Dublin Cycling Campaign

30 August 2022

Blanchardstown to City Centre Core Bus Corridor (Case: 313892)

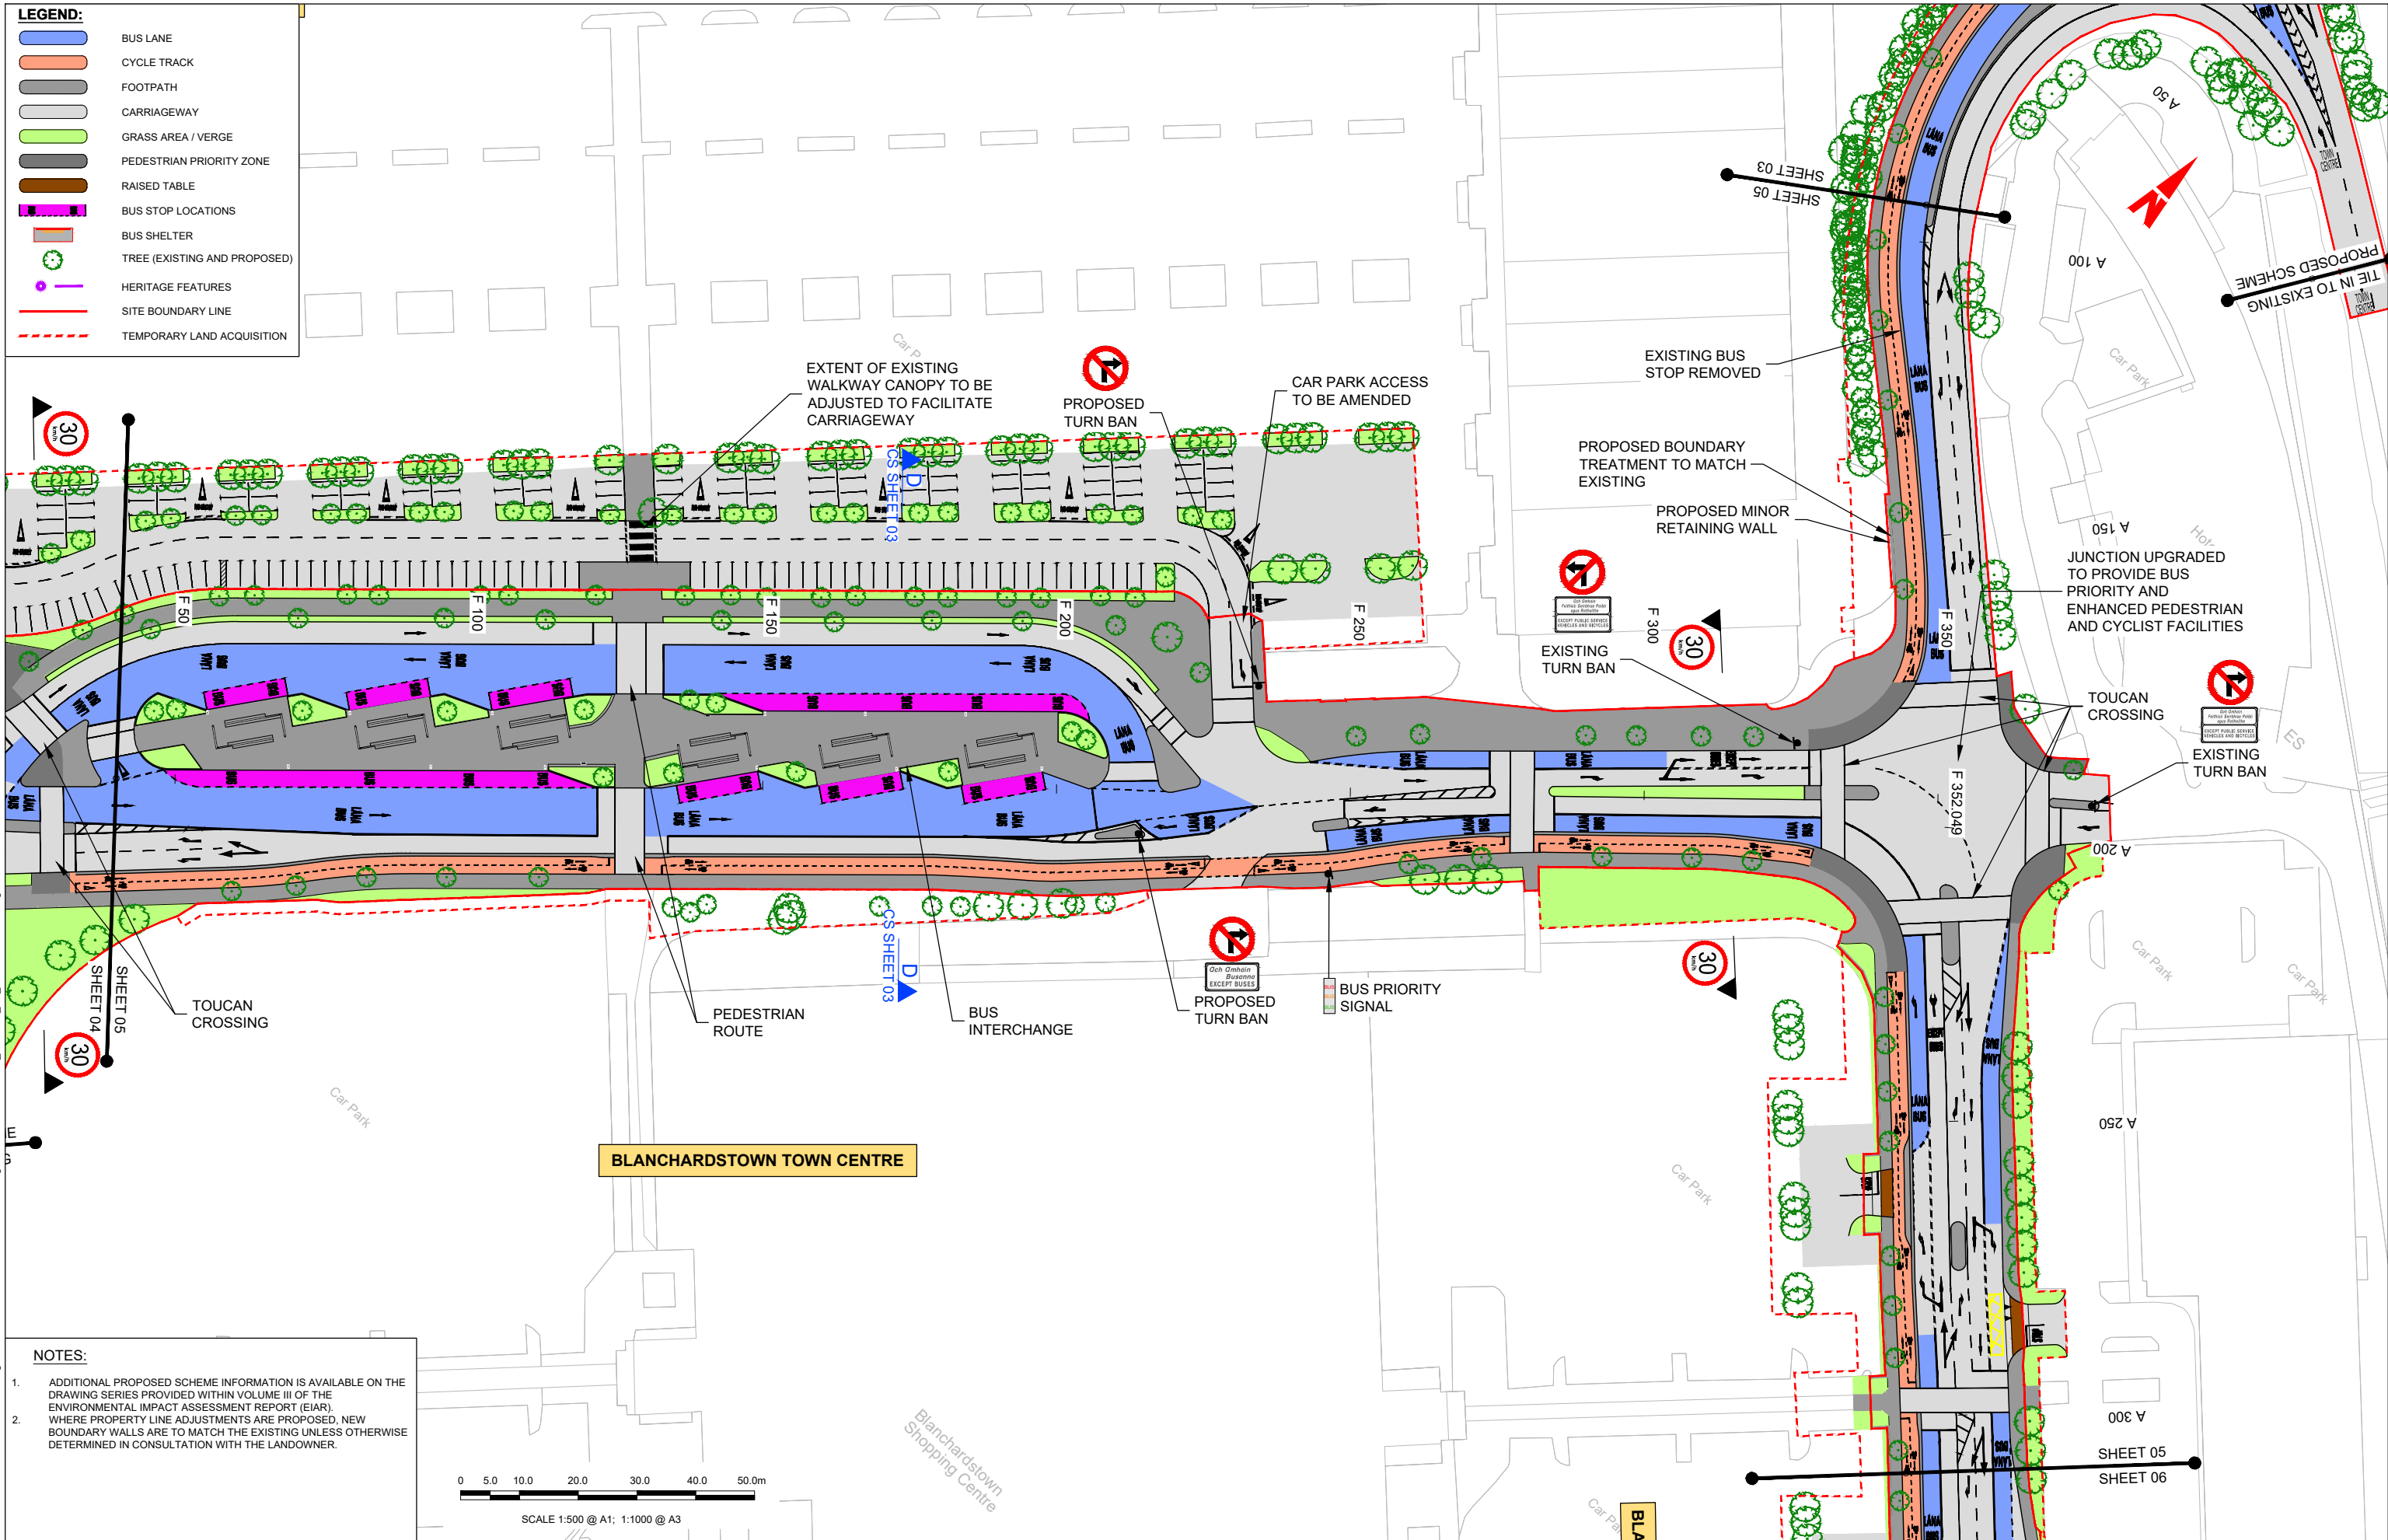
For example, "*TIA Sub Appendix 2 - Junction Design Report*" shows the design evolution of the Blanchardstown Road South / Blakestown Way junction (general arrangement drawing sheet 4). The July 2021 iteration re-adds a left-turn slip for general traffic in order to improve junction capacity for motor traffic (as shown in Figure 1 below).

Proposed vehicle slip lanes, where vehicles can cut across people cycling, sometimes at relatively high speeds, are proposed once again, particularly in the Blanchardstown area. None of the junctions around Blanchardstown reflect any of the four junction types developed in the '*Preliminary Design Guidance Booklet for BusConnects Core Bus Corridors (PDGB) (NTA 2021)*' in Appendix A4.1. This issue of inappropriate slip lanes has been raised through the various iterations of this scheme, and yet remains to be comprehensively addressed.

Note the conflicting rationale stating the addition of a vehicular slip lane brings the junction into line with BusConnects PDGB principles. As stated previously, none of the junction types outlined in PDGB recommend slip lanes.

DMURS 4.4.3 states that designers "*should omit left-turn slips as they encourage high traffic speeds and are highly disruptive for people walking and cycling*". As per the present [National Cycle Manual](#) Section 7.8, the vehicle slip lanes should be removed, particularly at this location in the context of a major town centre.
